From: Martyn White <Martyn.White@arun.gov.uk>
Sent: 20 December 2019 15:48
To: Planning.Responses <Planning.Responses@arun.gov.uk>
Subject: AW/294/19/HH

AW/294/19/HH

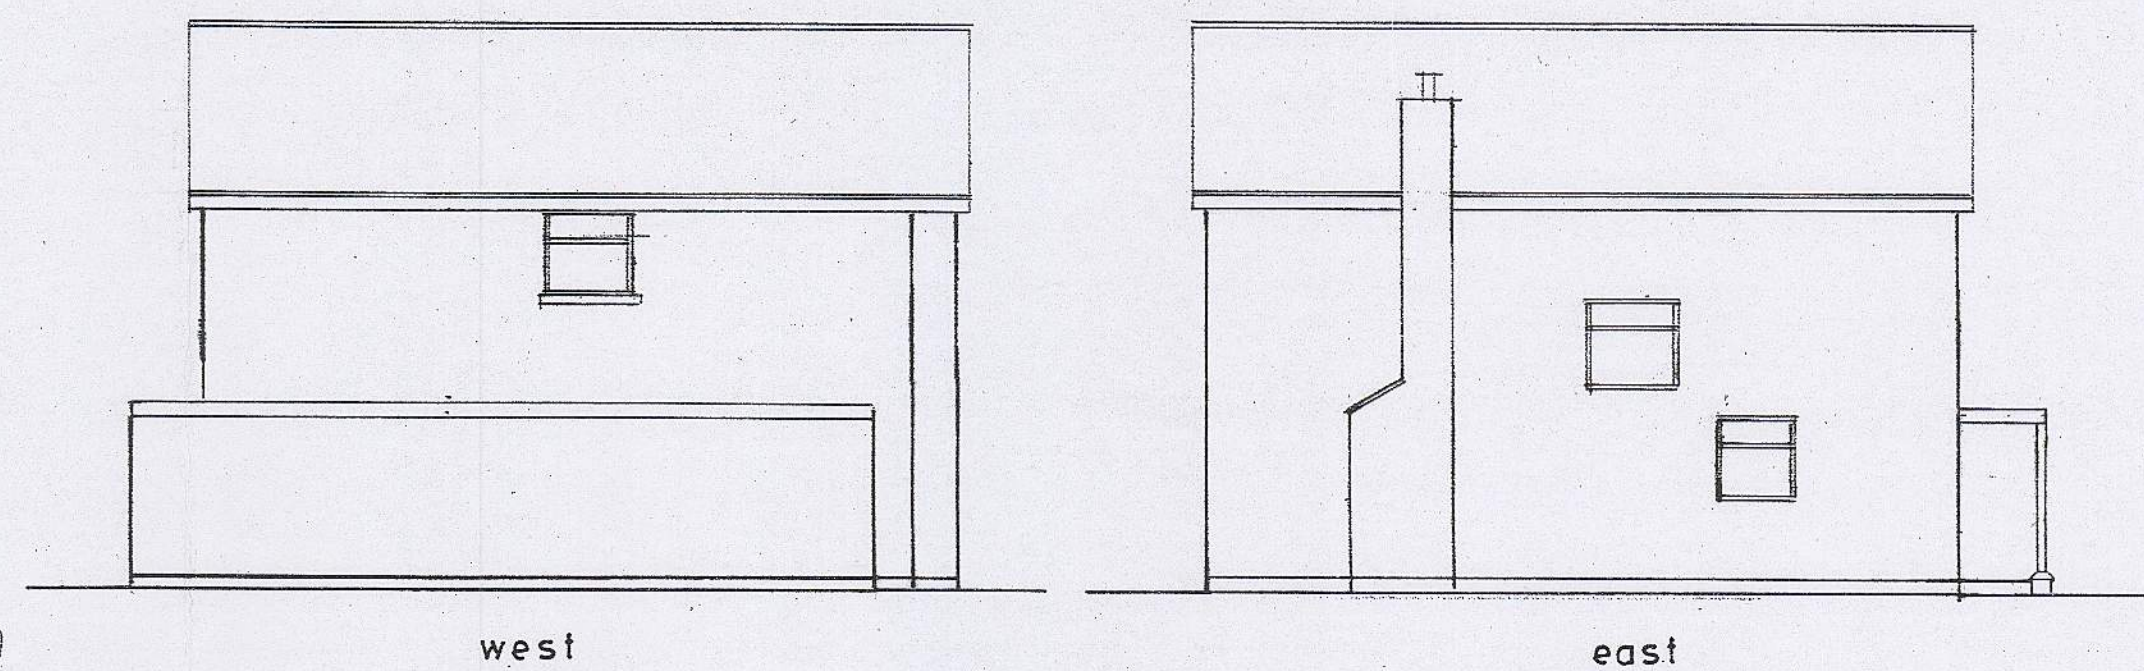
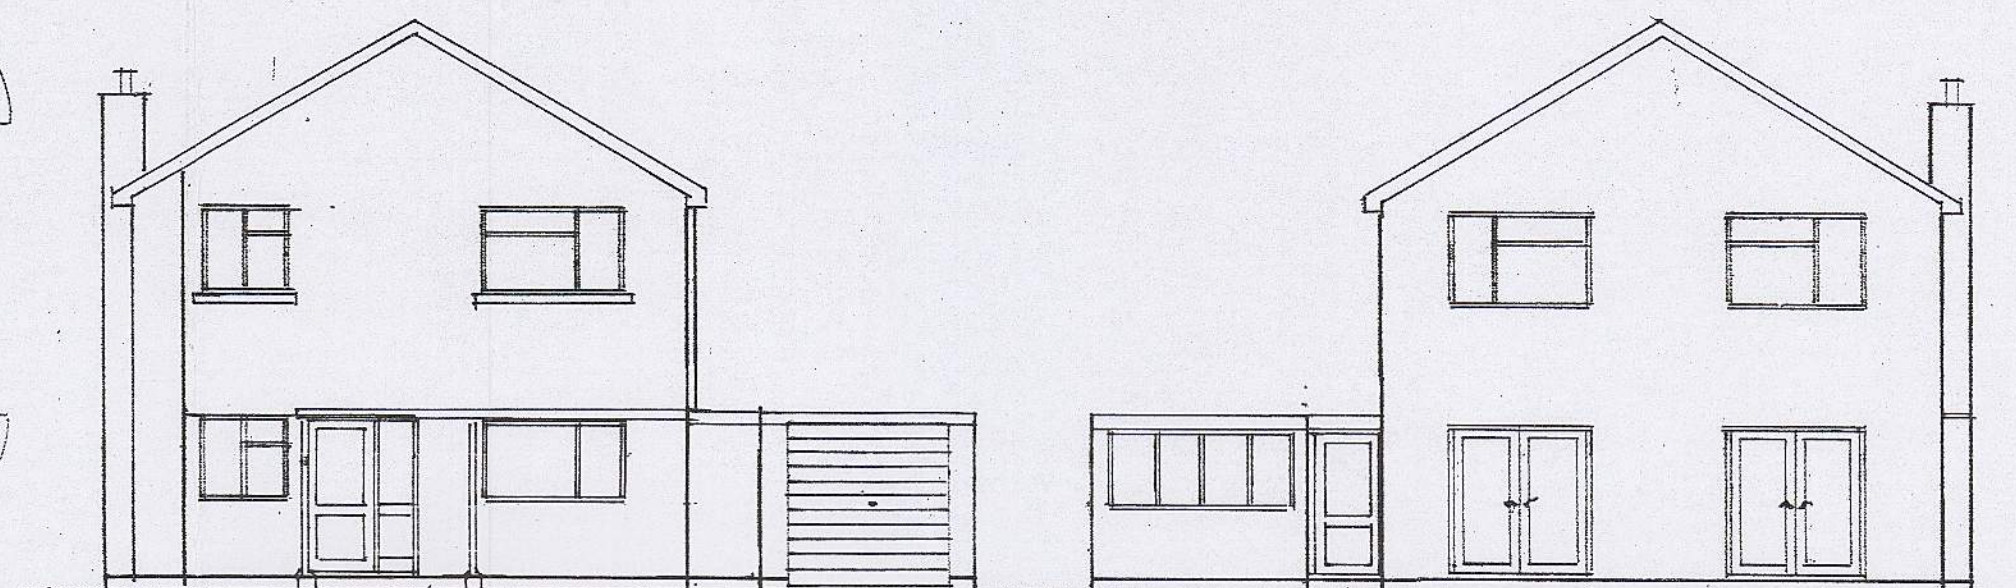
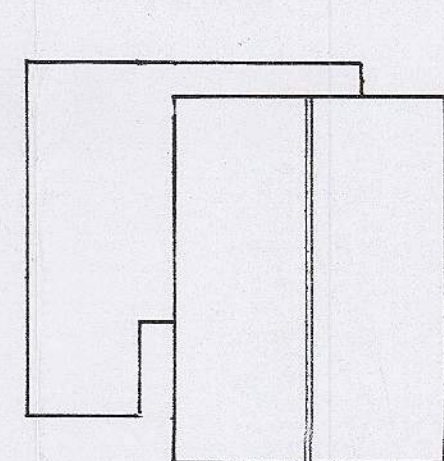
Relocating the window and door will simplify the front elevation of the property, and not cause harm. Likewise, the proposed porch will have a neutral impact, subject to the careful use of materials (to match existing).

I do have some concerns regarding the proposed elevation treatment, in that it is not necessarily based on the identified characteristics of the conservation area. It is more modern in appearance, and somewhat out of character. It may be that such a design will have a neutral impact, but this is subject to the careful consideration of the materials and the colours used. I note that timber is proposed for the cladding, which would help to soften the appearance.
